From: Jamie Brown
Sent: 08 September 2016 14:48
To: Planning.Responses
Subject: AL-83-16

**WEST SUSSEX COUNTY COUNCIL
STRATEGIC PLANNING CONSULTATION**

SUBJECT: AL/83/16/OUT-Outline application with all matters reserved for residential development of up to 8No. dwellings & associated works including access, landscaping & open space. This application is a Departure from the development plan. Resubmission of AL/8/16/OUT.

Land south & west of Barnside & east of pond, Hook Lane, Aldingbourne, West Sussex

Client	Whitgift Estates			
Project	Hook Lane, Aldingbourne			
Drawing Title	Access Arrangements and Vehicle Swept Path Analysis			
Scale	Varies @ A3	Drawn By	RAA	Checked By
Drawing No.	2015/2717/001	Date	December 2015	Approved By
				PMR
				Rev.
				A

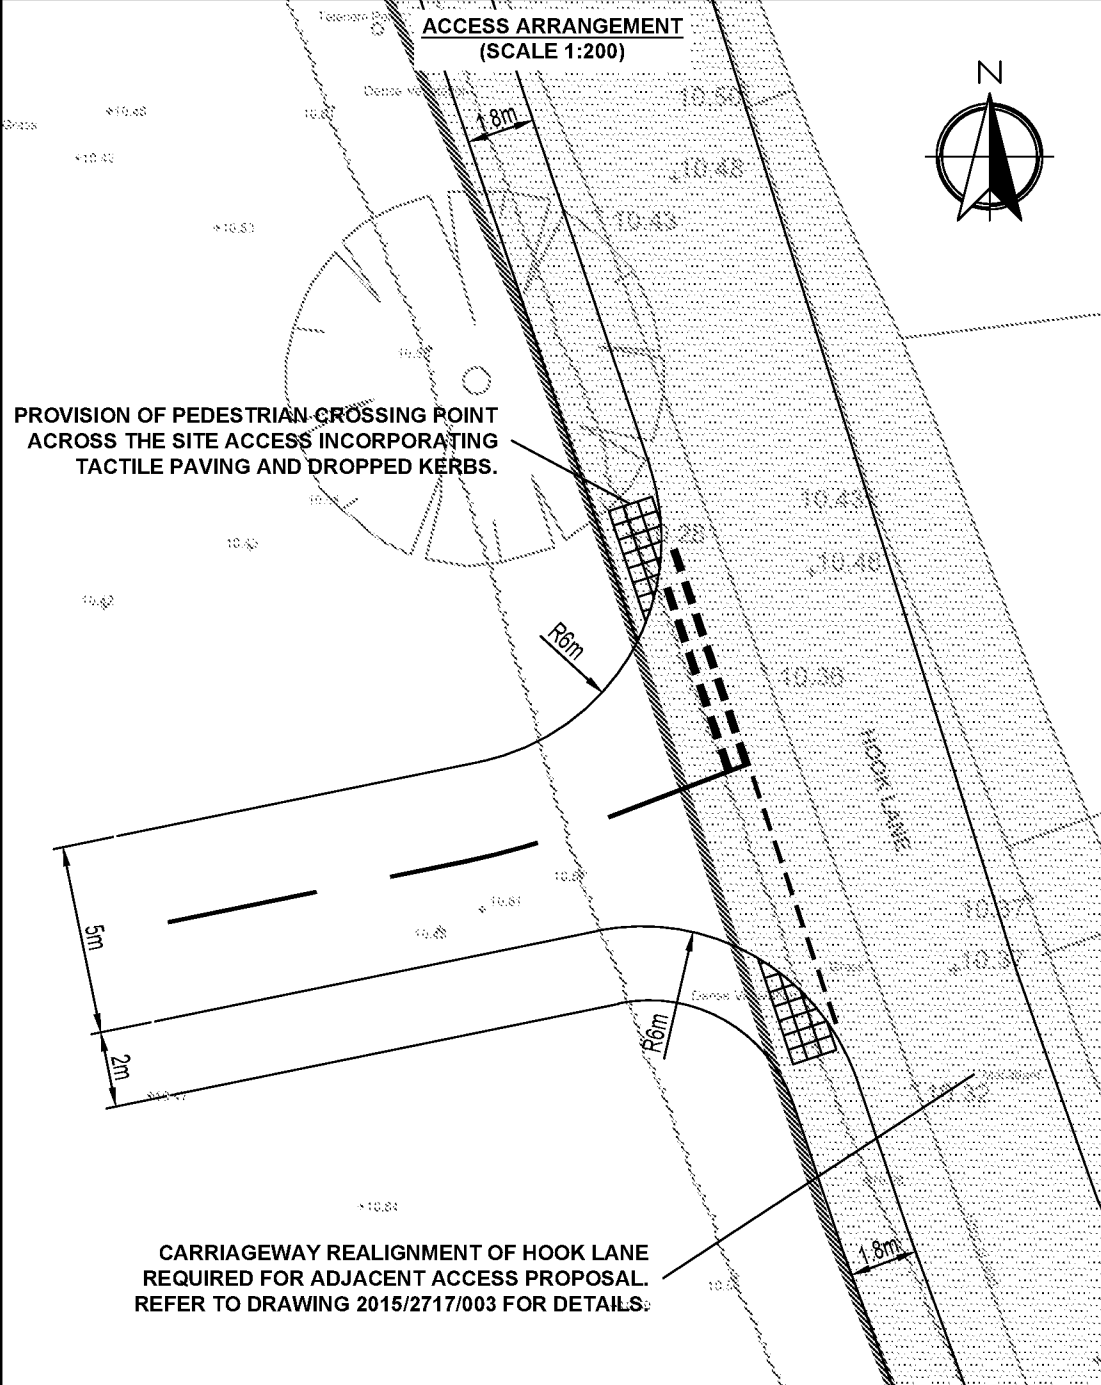
The TS demonstrates that large vehicles are able to enter and exit the site in forward gear and although this requires the crossing of the carriageway centre point, such movement would be acceptable given the infrequent nature and low volume of traffic.

Client	Whitgift Estates			
Project	Hook Lane, Aldingbourne			
Drawing Title	Access Visibility Splays			
Scale	1:500 @ A3	Drawn By	RAA	Checked By
Drawing No.	2015/2717/002	Date	December 2015	Approved By
				PMR
				Rev.
				A

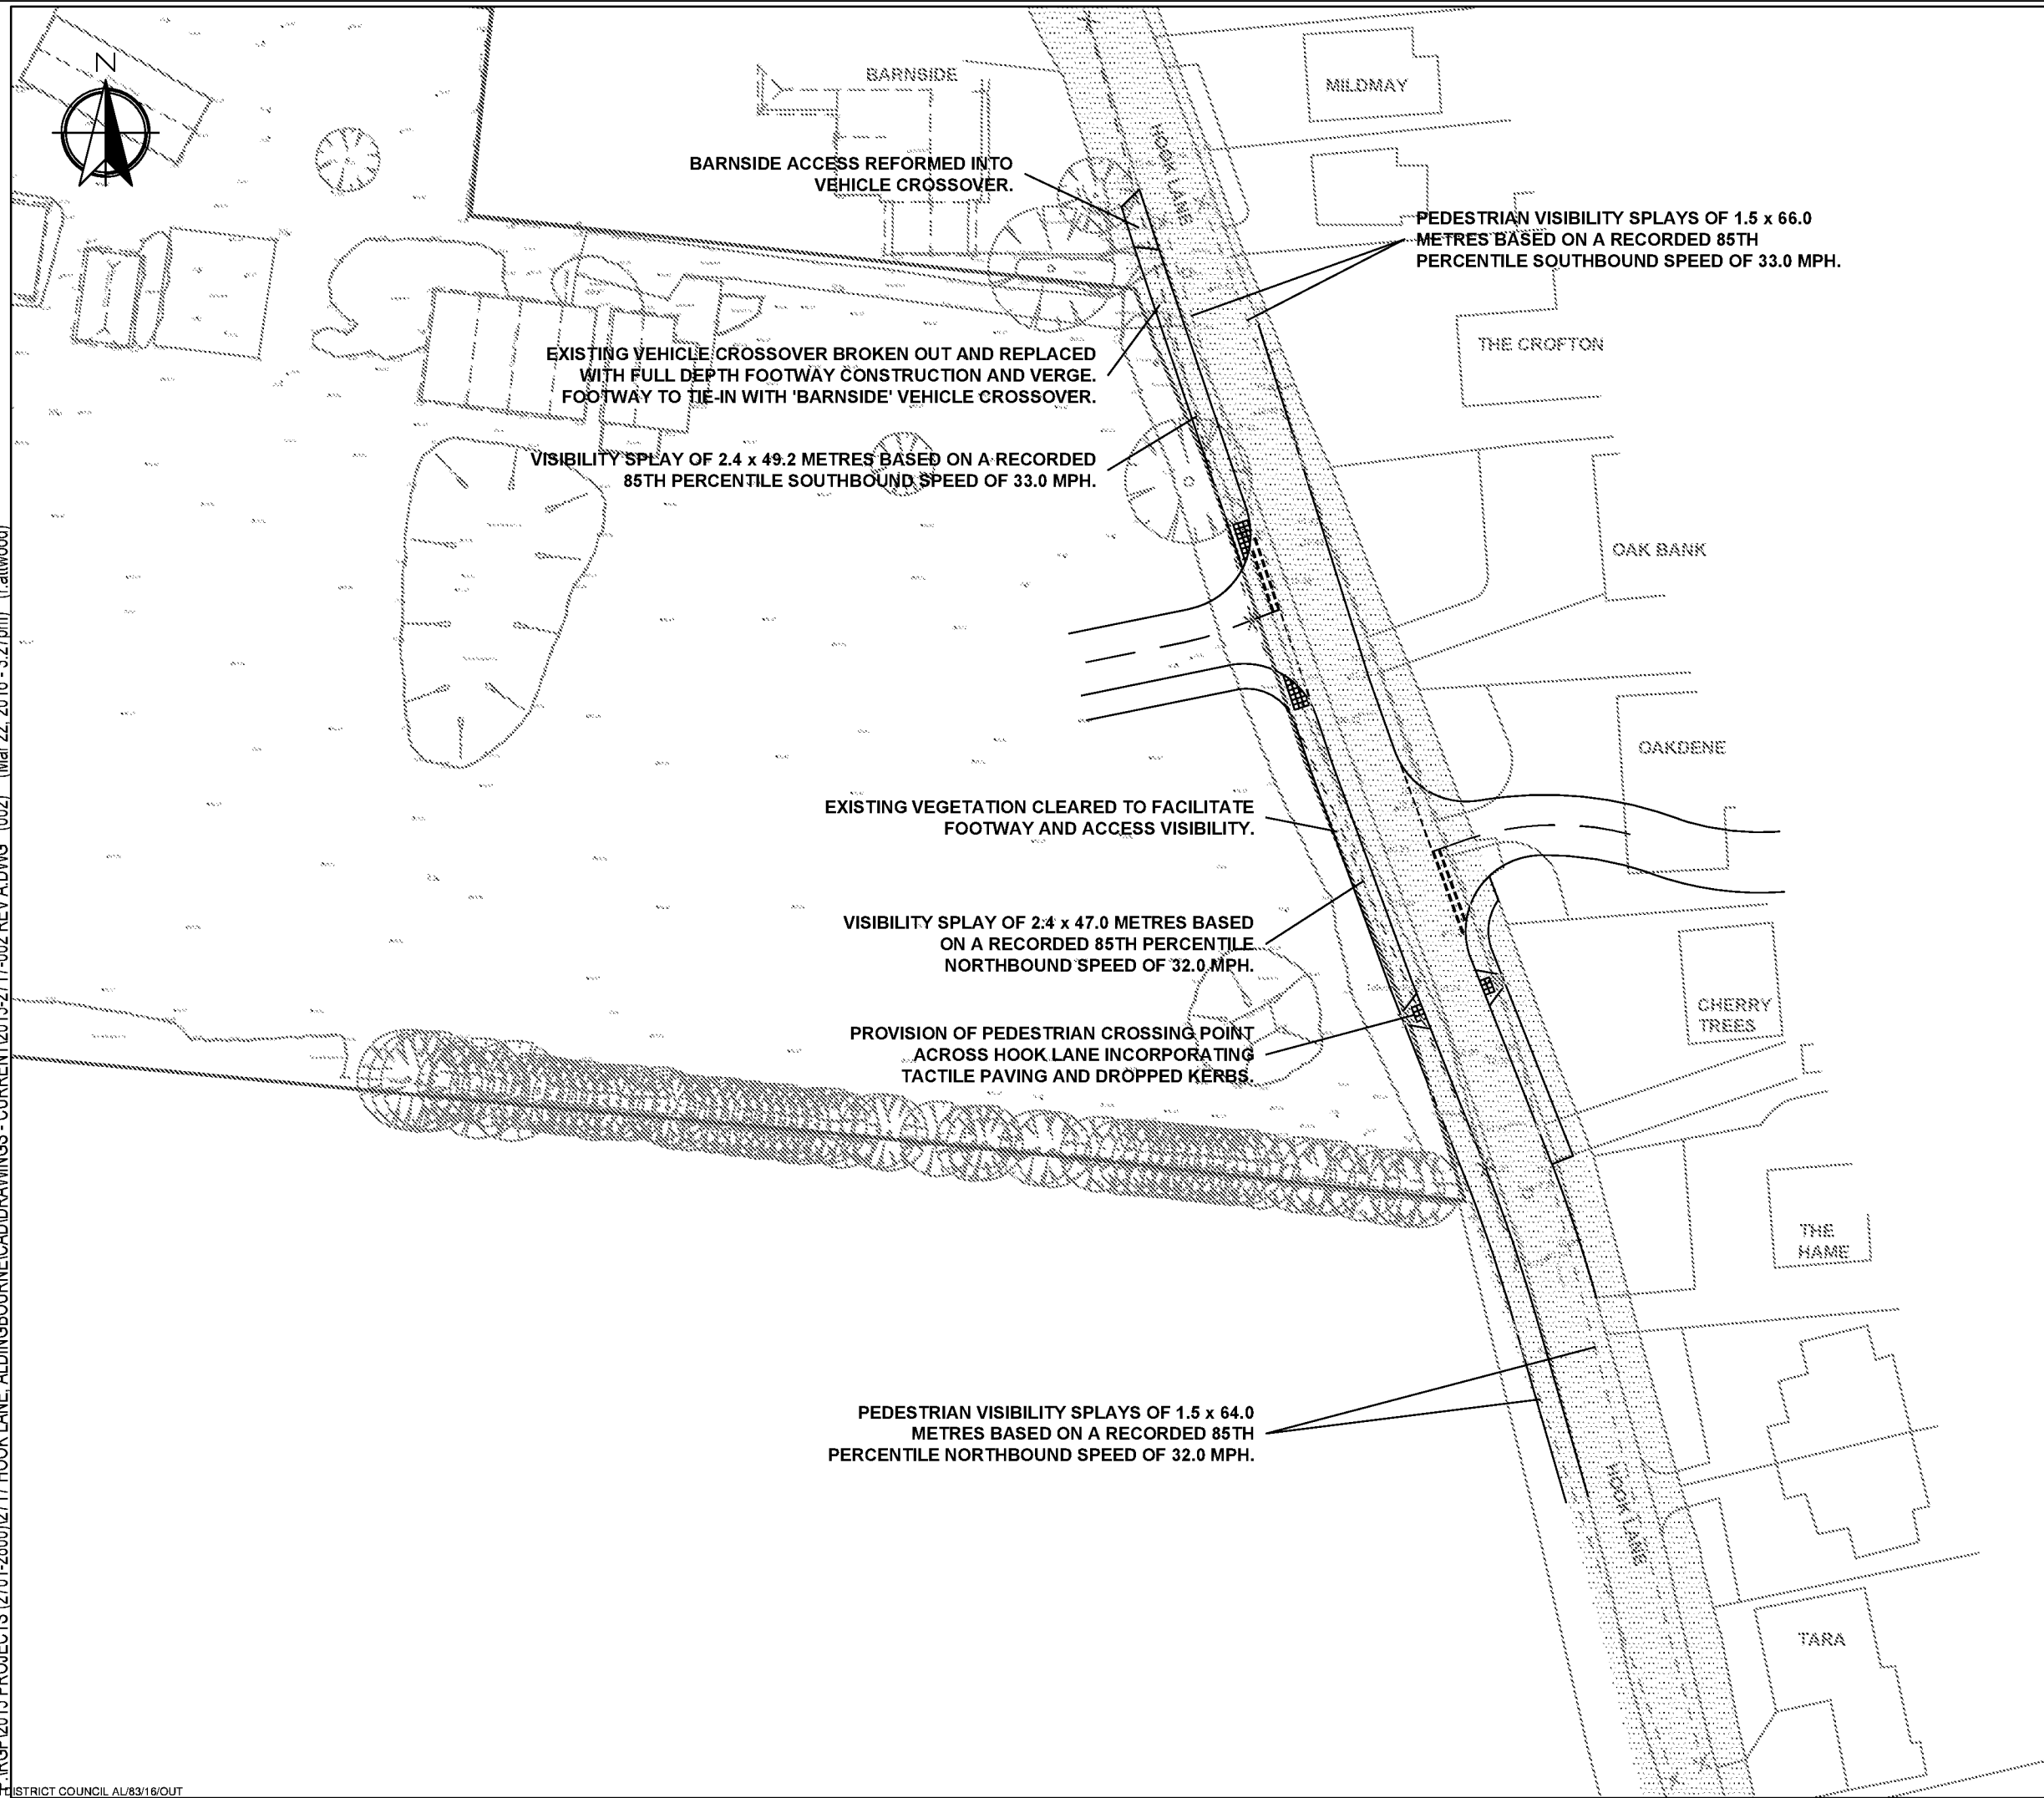
The proposed visibility splays, taken from a setback of 2.4m, extend 47 metres to the north and 49 metres to the south. The splays provided are considered acceptable for the development with the speed survey taken into account. MfS does provide some allowance for occasional on-street parking within the visibility splay and it would appear that in this area, where most properties have some sort of off-street parking facility, that there is not an extensive demand for on-street parking in the local vicinity.

No part of the development shall be first occupied until visibility splays of 2.4 metres by 47 to the north and 2.4 by 49 metres to the south have been provided at the proposed site vehicular access onto Hook Lane in accordance with the approved planning drawings. Once provided the splays shall thereafter be maintained and kept free of all obstructions over a height of 0.6 metre above adjoining carriageway level or as otherwise agreed.
